CITY OF ALBUQUERQUE

**Re: Storage Building
9324 Susan SE
Traffic Circulation Layout
Engineer's/Architect's Stamp 8-14-24 (L20D079)**

Based upon the information provided in your submittal received 10-7-24, the above referenced plan cannot be approved for Building Permit until the following comments are addressed:

BICYCLE RACK

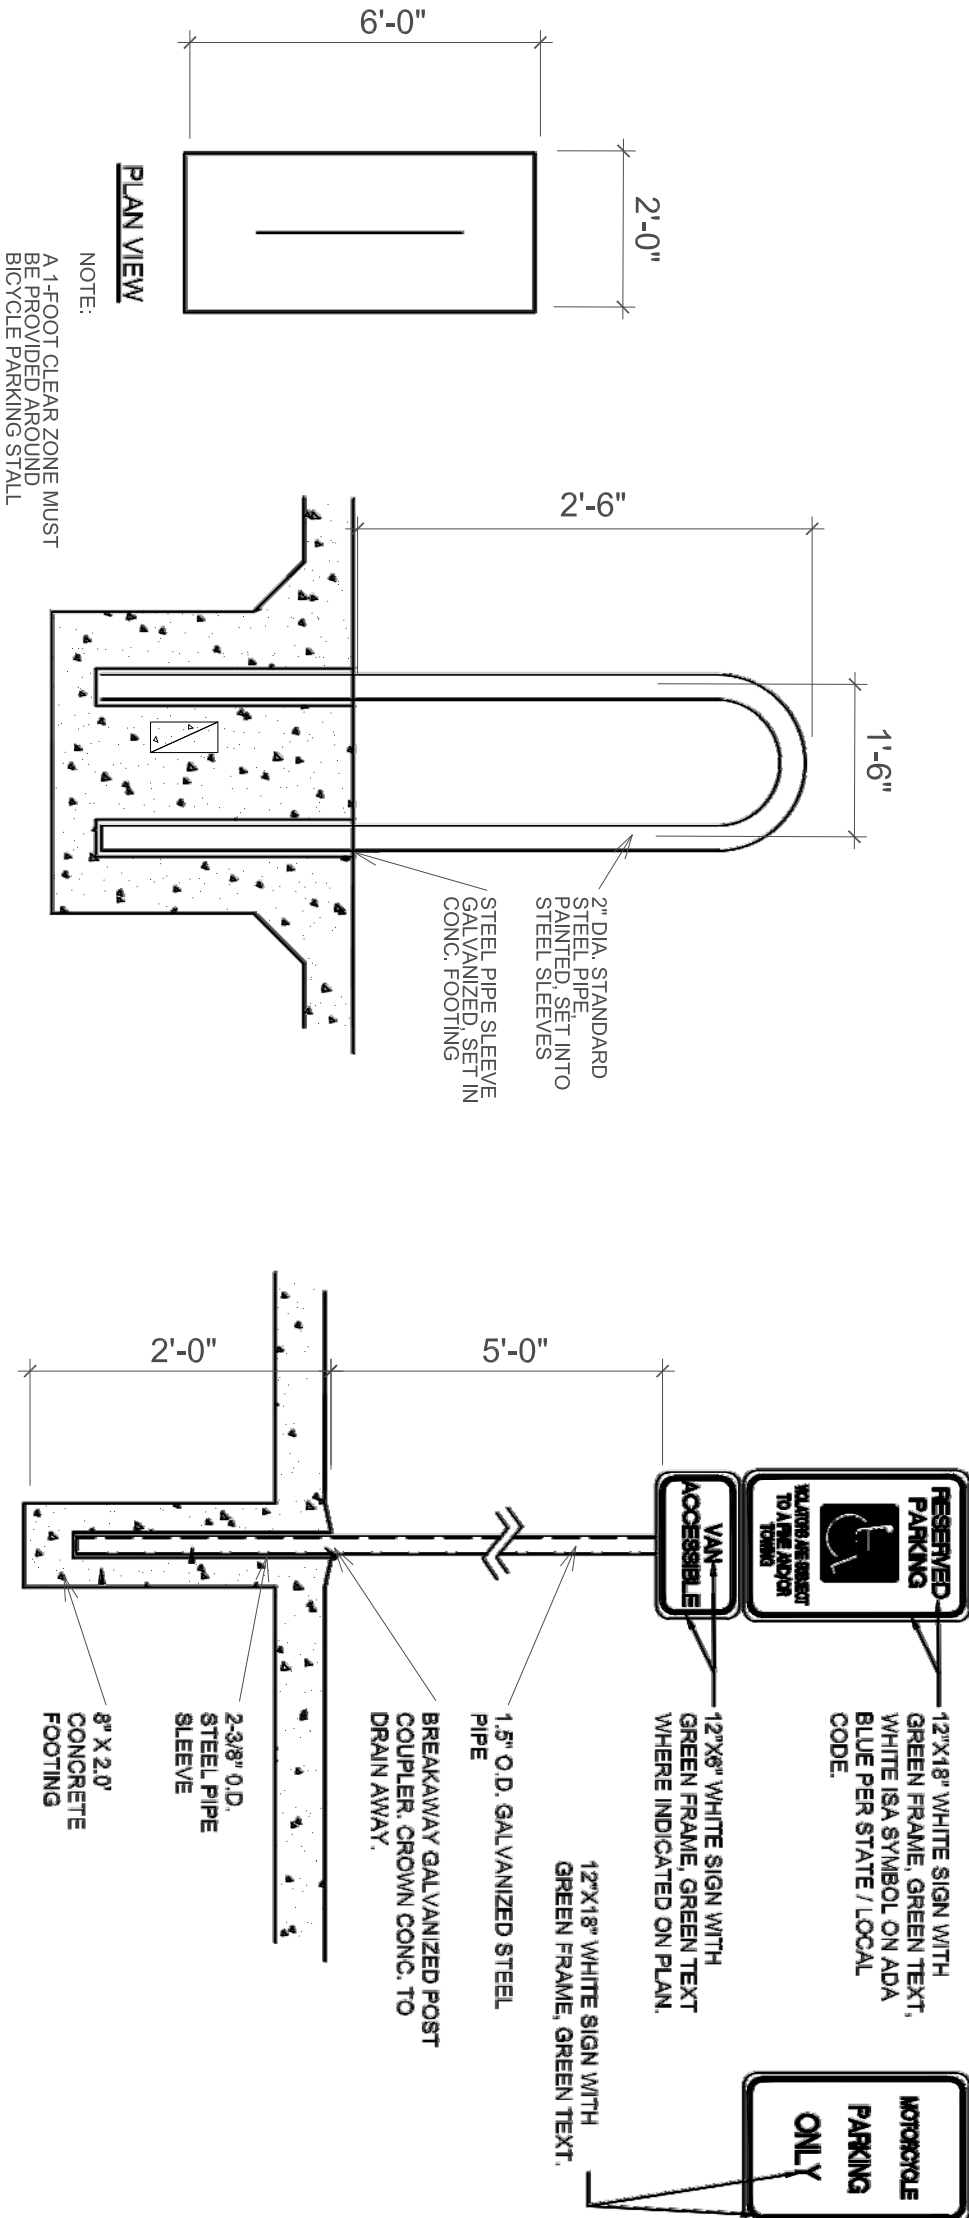
1. Revise the List of number of parking spaces required by the IDO for bicycle parking. The minimum is 3 spaces. Please revise the Bicycle Rack details to show two racks.

TCL PLAN

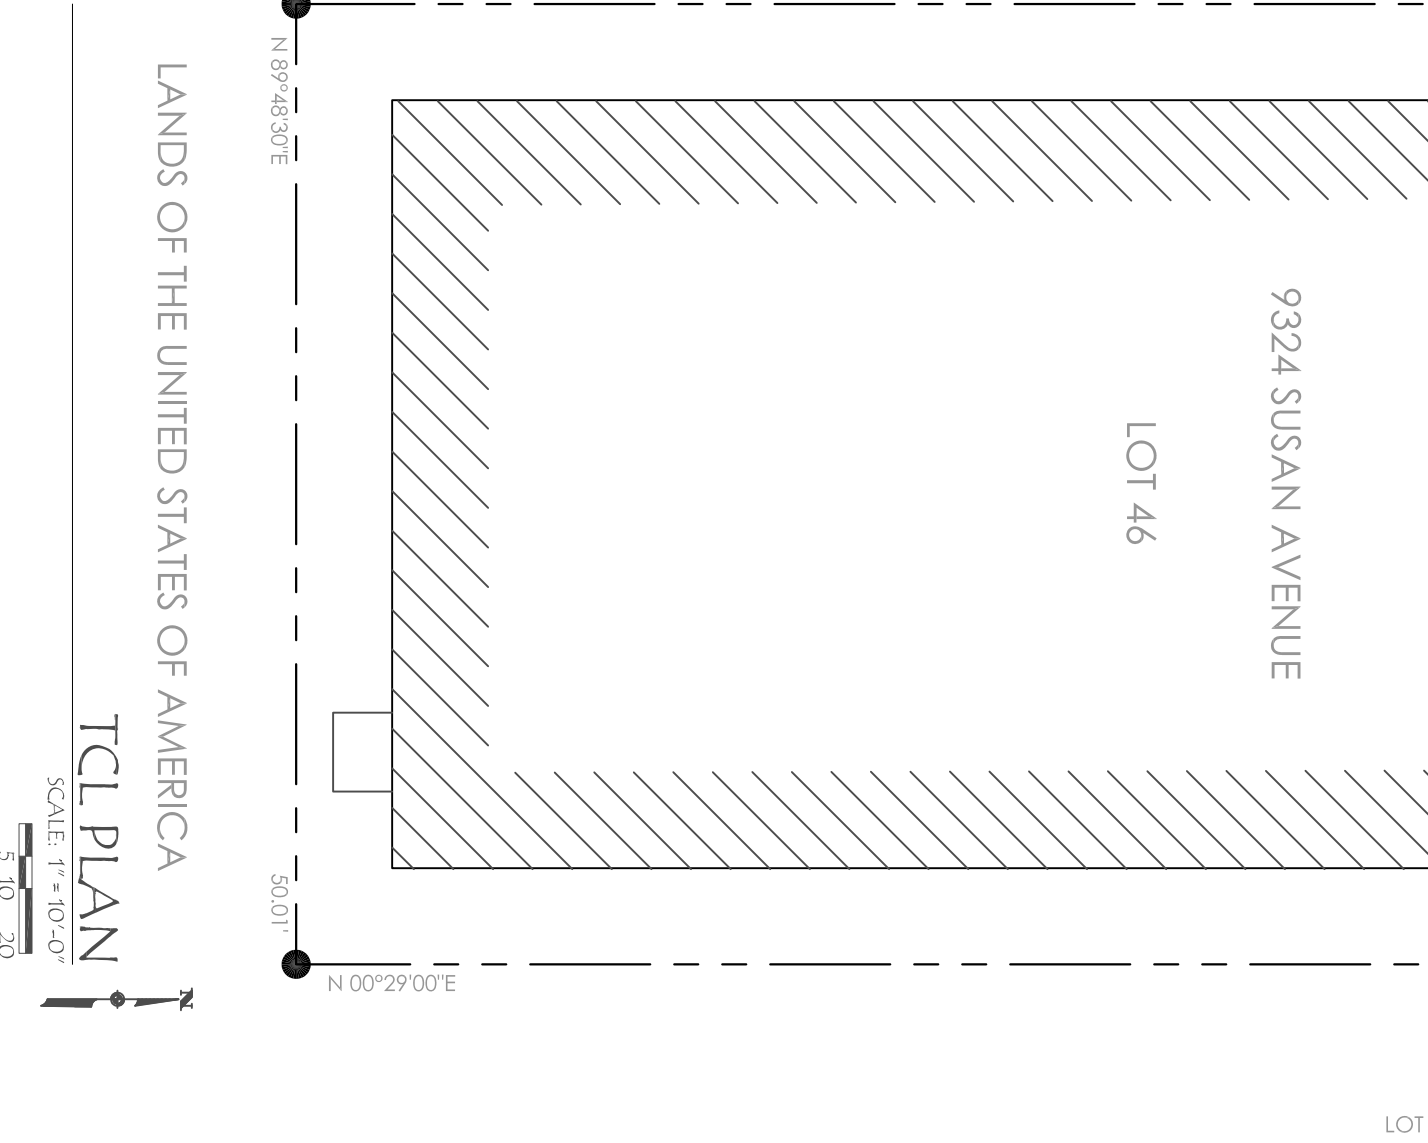
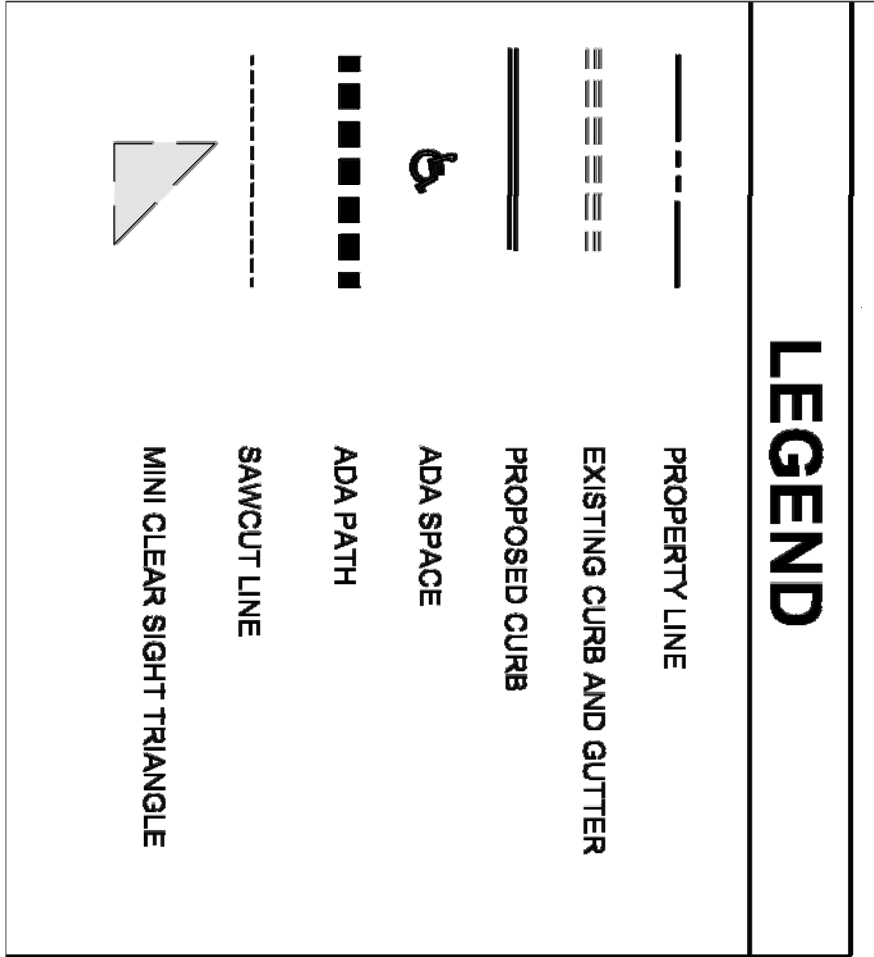
2. The scale and North Arrow must be shown on the plan. A scale of 1"=20' is recommended.
3. Identify the existing right of way, sidewalk, buffer/Landscape, curb cuts, street widths along Susan Ave.

4. Maximum access width for local streets is 22'-24'. Show this on the plan.
5. Please show the width and length for all the proposed parking spaces. All dimensions on the plan are missing.

6. Van accessible aisles should be 8ft wide. Please revise your plan.
7. A 1-foot clear zone around the bicycle parking stall shall be provided. Show this on the plan.

8. Per the DPM, a 6 ft. wide ADA accessible pedestrian pathway is required from the public sidewalk to the building entrances. Please clearly show this pathway and provide details.

9. Per DPM, a 6 ft. wide ADA accessible pedestrian pathway is required from the ADA parking stall access aisles to the building entrances. Please clearly show this pathway and provide details.

12. Show the clear sight triangle and add the following note to the plan: "Landscaping and signage will not interfere with clear sight requirements. Therefore, signs, walls, trees,

and shrubbery between 3 and 8 feet tall (as measured from the gutter pan) will not be acceptable in the clear sight triangle.
